From: Simon Davis
Sent: 09 January 2019 15:21
To: Planning.Responses
Subject: FW: Planning Consultation on: BR/263/18/PL
Attachments: 180913 - 129 Site Block Plan Rev06.pdf

Application for variation of conditions following grant of planning permission BR/348/16/PL relating to Cond 2 (Block plan & smoking shelter) and Cond 9 (smoking shelter materials).

CLIENT Butlins Skyline Ltd.
PROJECT St Josephs
DRAWING TITLE Smoking Shelter

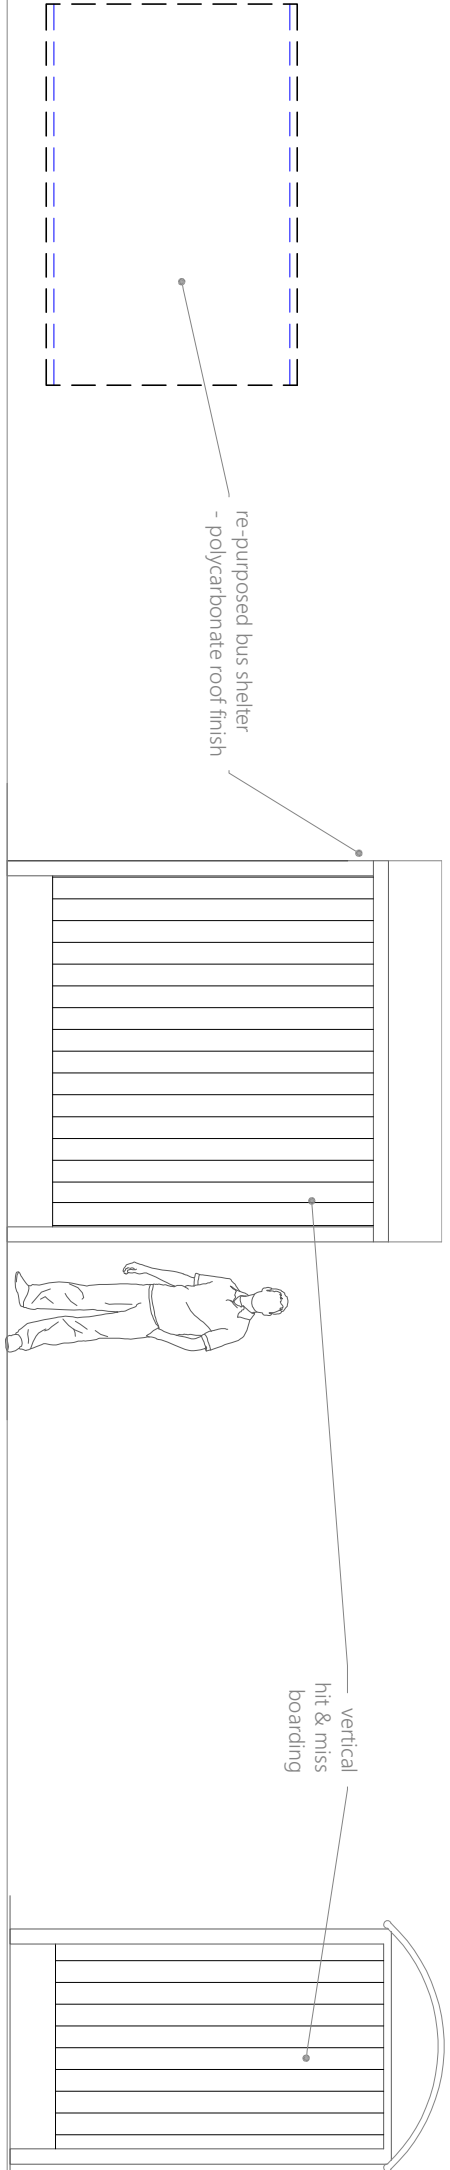
Sorry, I also need you to change the submitted block plan 129/2.010/05 to remove the reference to "Adjusted Hours of Use" (Conservatory) and to amend the relocated smoking shelter annotation to refer to 2 people not 6. Please can you also confirm whether the smoking shelter drawing is to be retained unchanged in the submission.

Please retain smoking shelter as unchanged. I am not aware of a change of design request.
